Our ref: New Liverpool Public School (SSD-10391)

1 April 2022

Subject: Request for Additional Information

Figure 1  
Architectural Site Plan

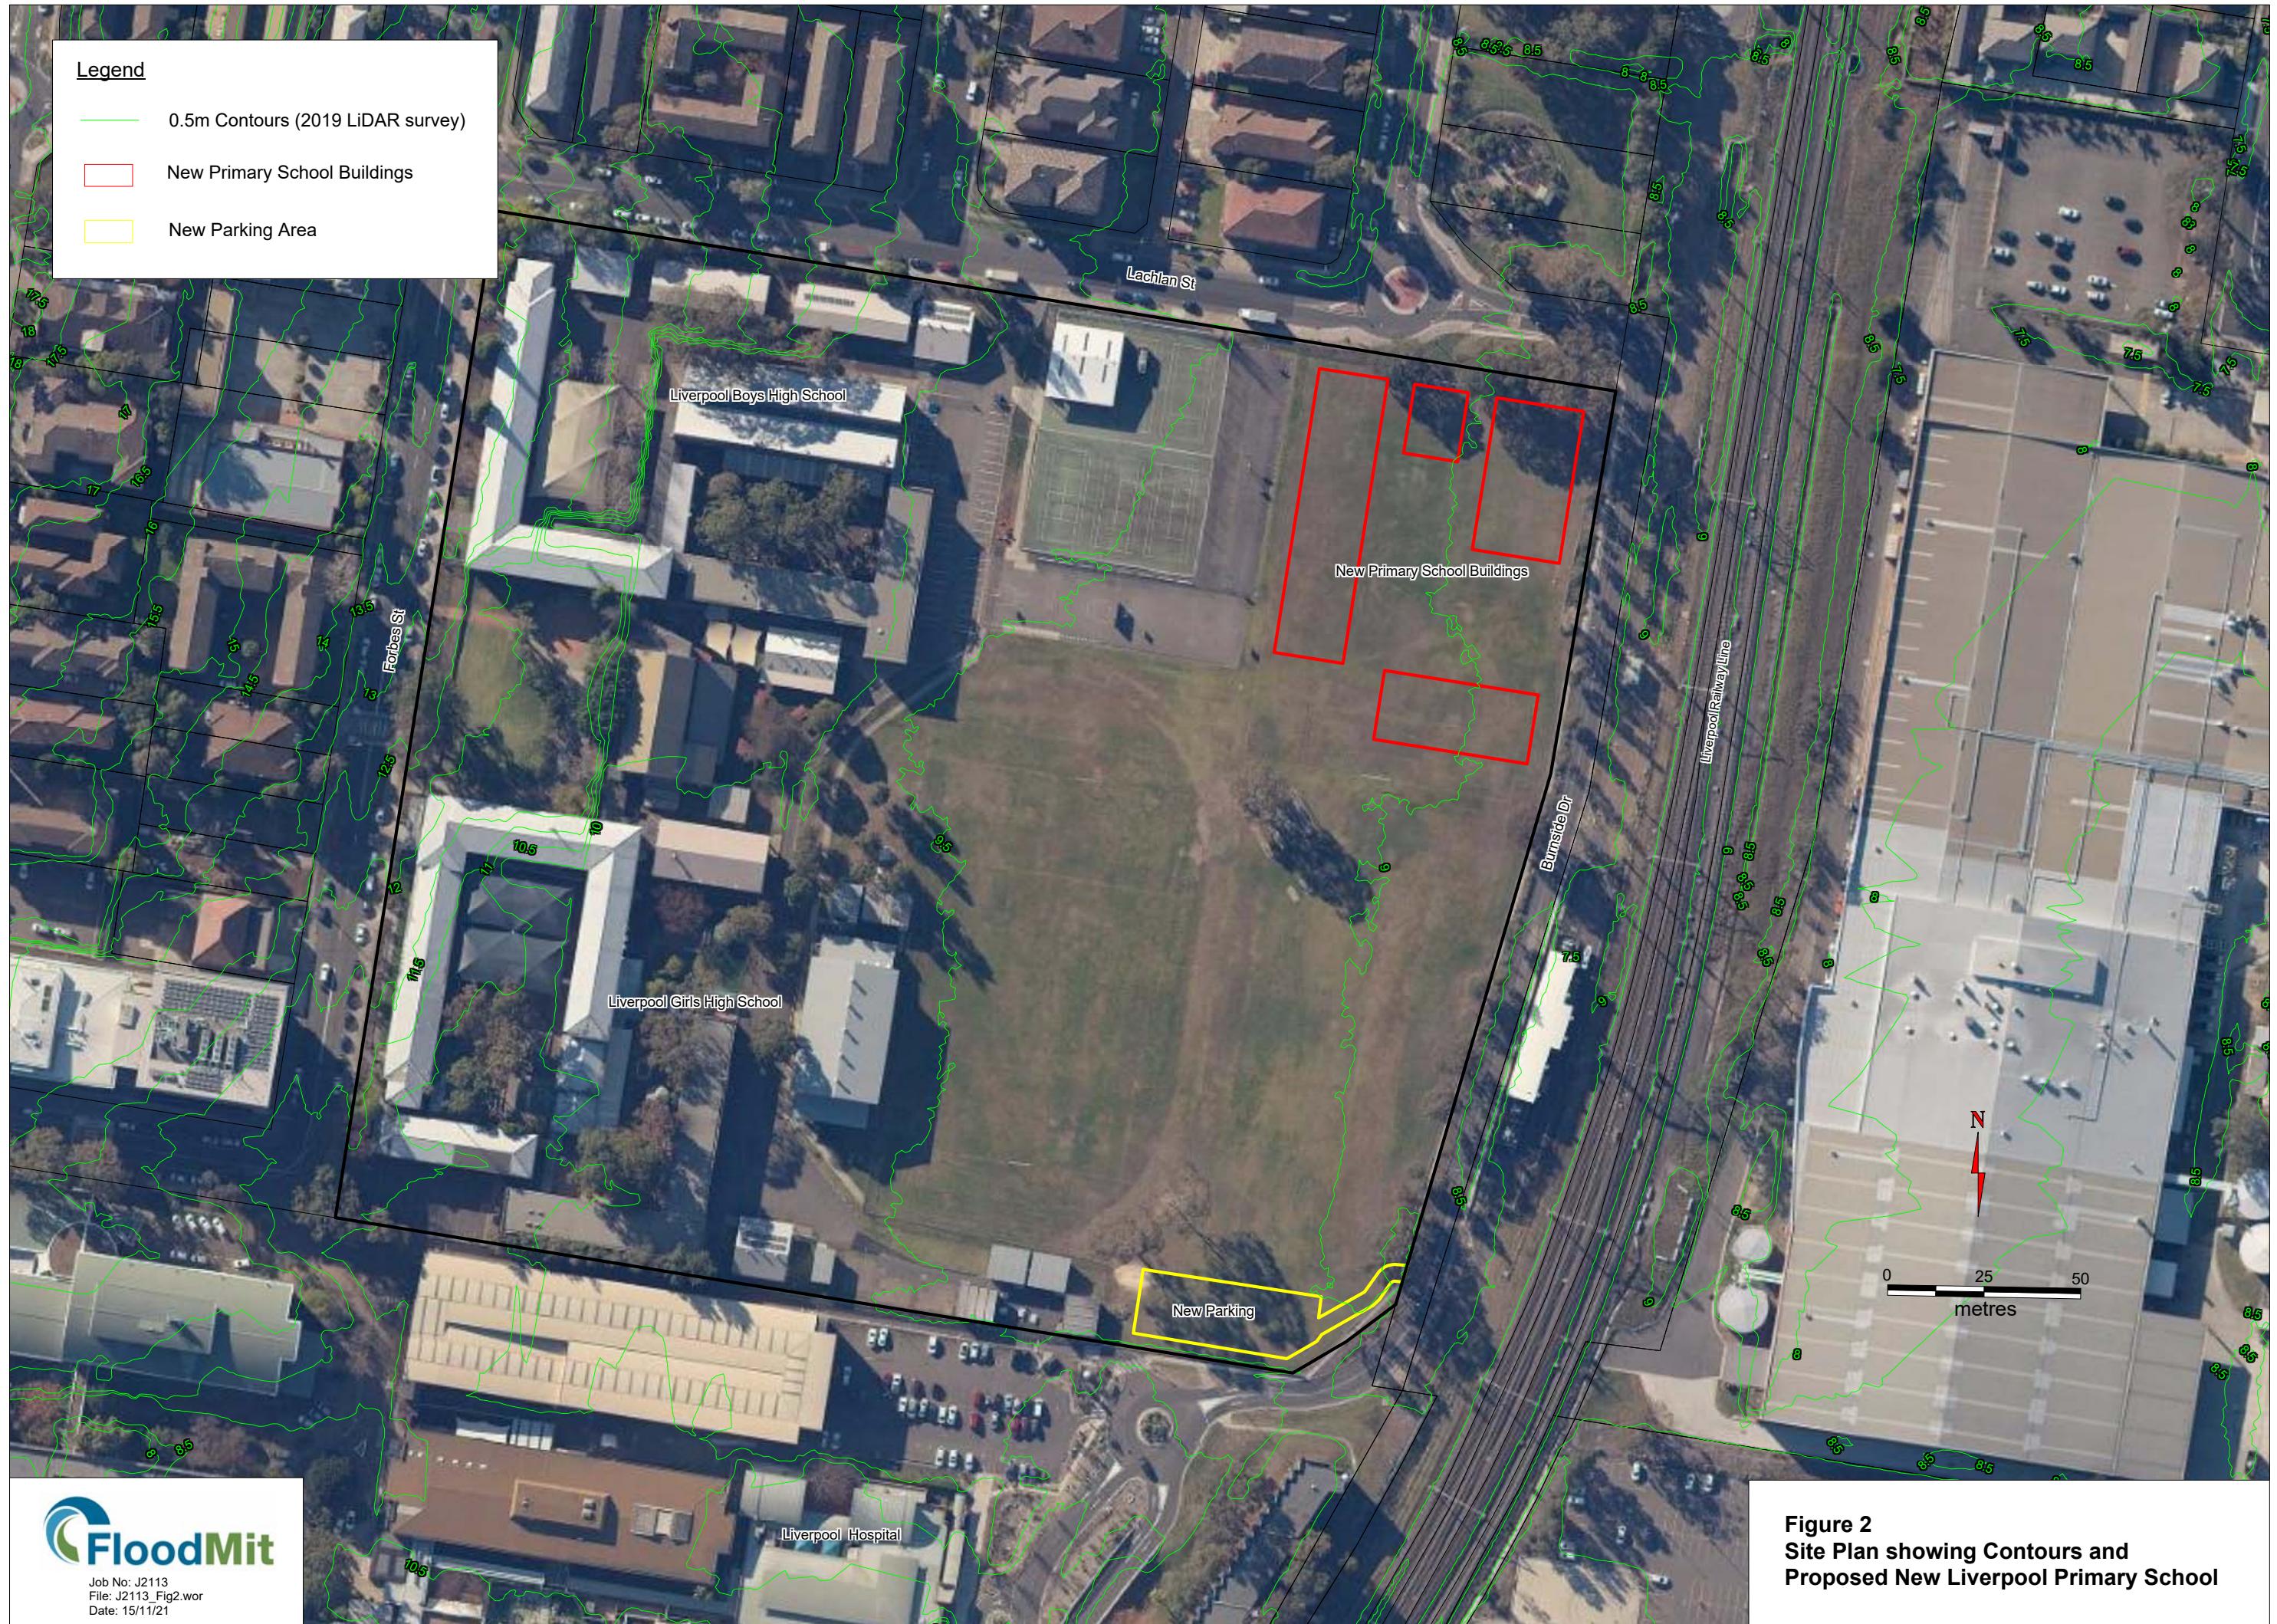
The following architectural plans are required to be amended to reflect the correct version, north point and the dates of the latest issue of the plans:

- *the site plan*: to reflect the works recently approved under Part 5 of the Environmental Planning and Assessment Act (EP&A Act).
- *drawing No NLPS-AR_DRG-0203, Rev No P3, dated 15/12/2021*: to show correct area for future preschool unencumbered external play area.
- *all relevant plans*: to show a consistent location of the 'general store'.
- *architectural drawings dated 18 February 2022*: to correctly reflect the date of amendment and the revision number (currently the drawings do not include the amendment version and are dated 17/12/2021, rev P5, which is the same as a previous superseded version of the drawings).
